KITTITAS COUNTY

MEMORANDUM

TO: All Staff
FROM: Public Works Plan Review Team
DATE: August 7, 2024
SUBJECT: BL-24-00014 McKeown

SITE PLAN
21584 HWY 97

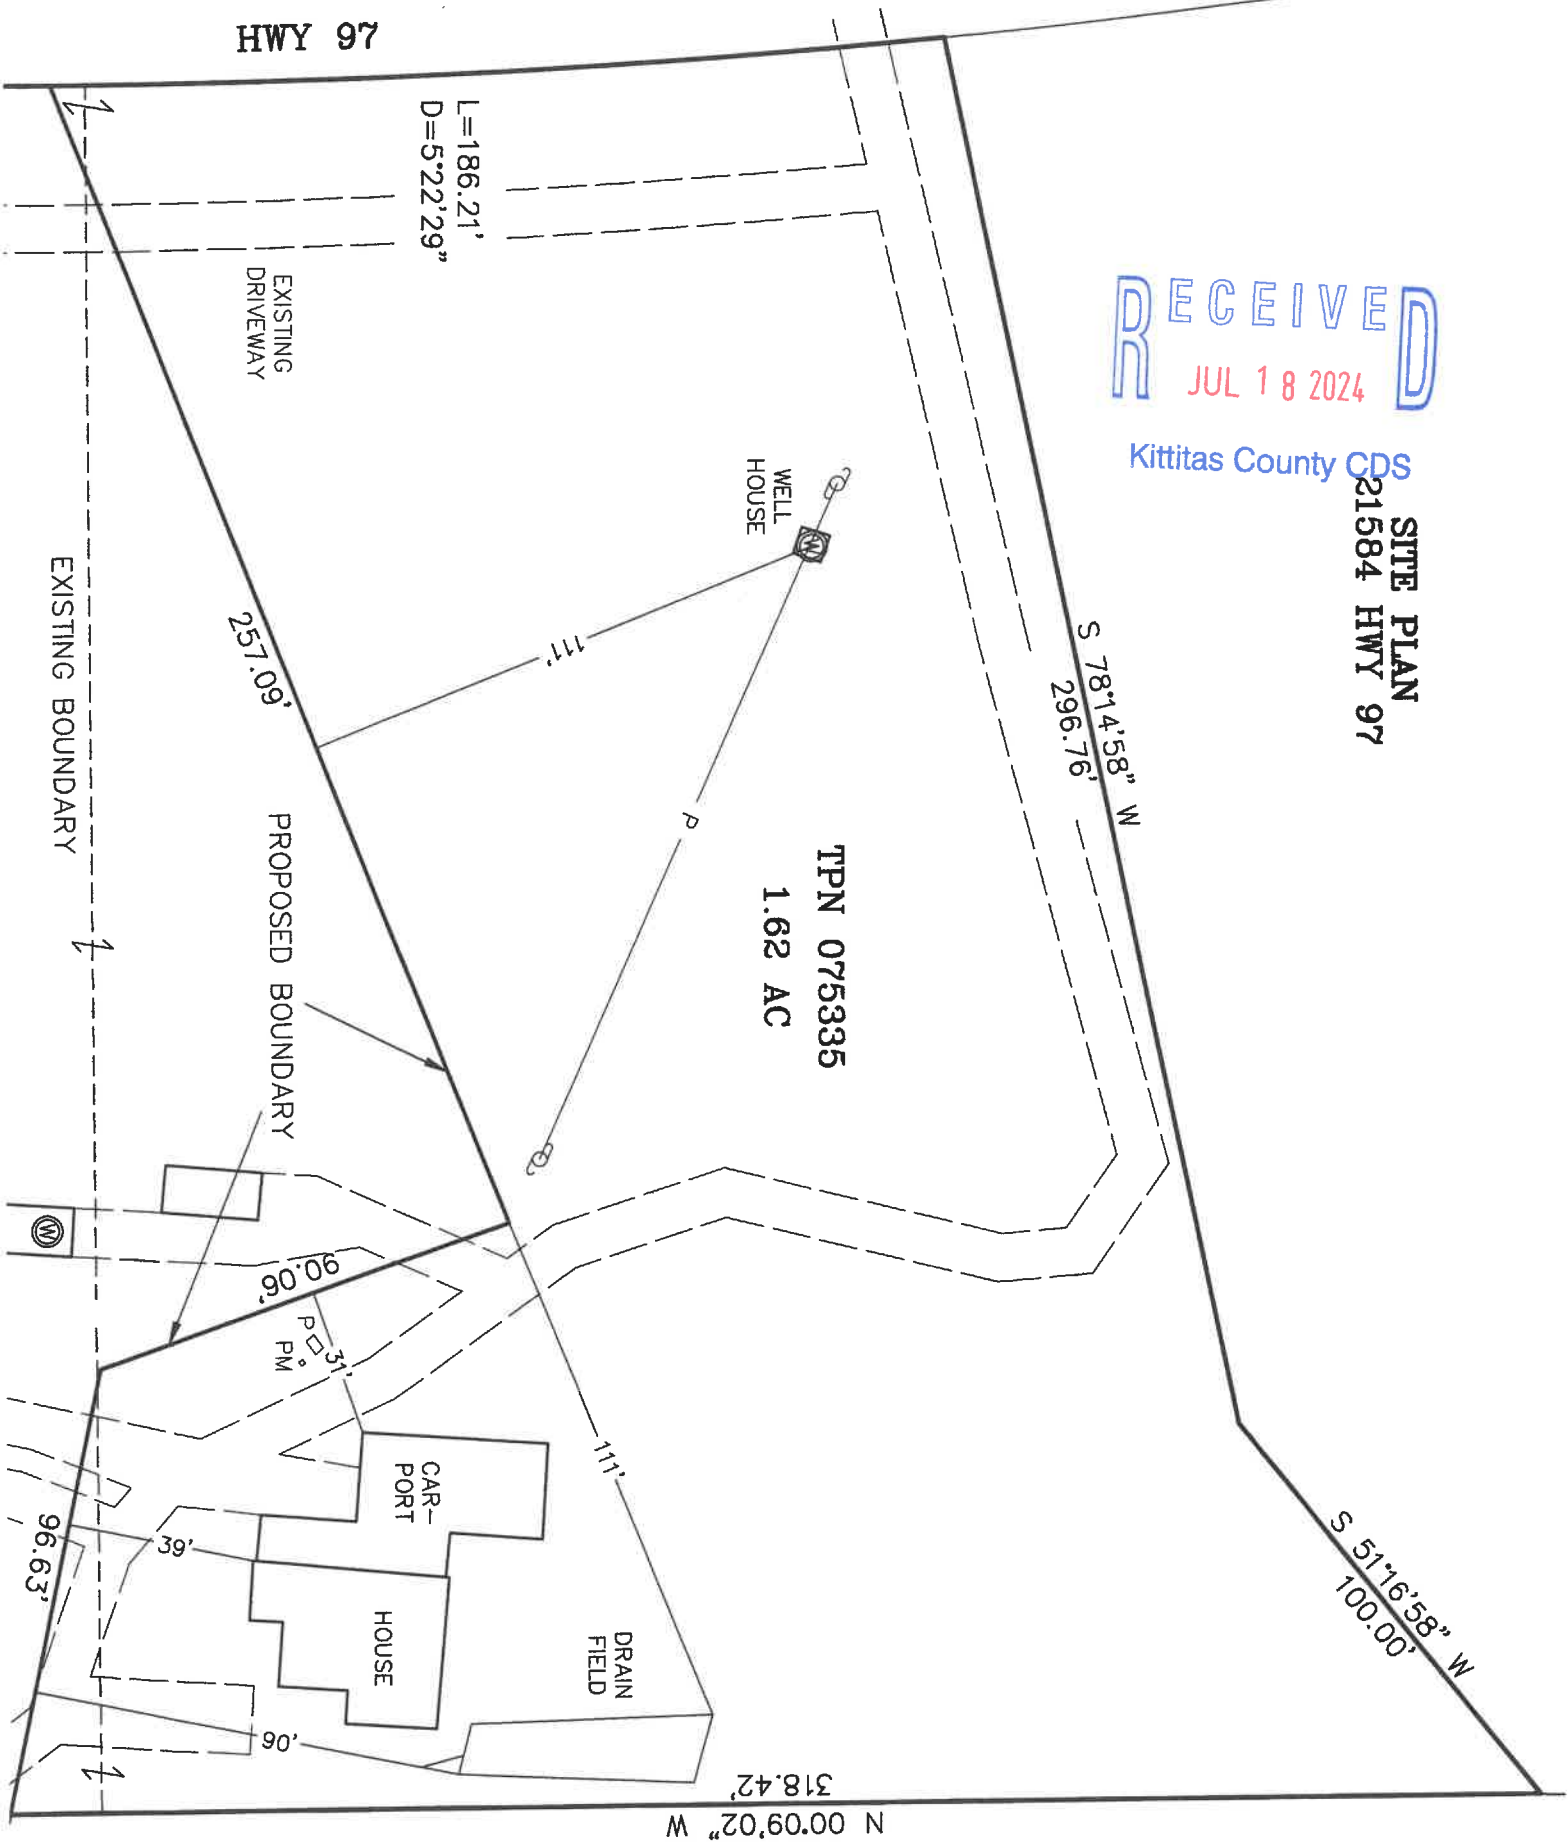
ACCESS	<ol style="list-style-type: none">1. No new connection to US 97 is permitted, existing access to be used.2. A recorded easement may be required.3. Maintenance of driveway approaches shall be the responsibility of the owner whose property they serve. The County will not maintain accesses.4. Any further subdivision or lots to be served by proposed access may result in further access requirements. See Kittitas County Road Standards.5. In addition to the above-mentioned conditions, all applicable Kittitas County Road Standards apply to this proposal. Access is not guaranteed to any existing or created parcel on this application. (JS)
ENGINEERING	Except as exempted in KCC 14.05.060, no grading or filling upon a site involving more than one hundred (100) cubic yards shall be performed without a grading permit from the County Engineer or Public Works designee (KCC 14.05.050). An application for grading in excess of five hundred (500) cubic yards shall be accompanied by an engineered grading plan (KCC 14.05.080). (CP)
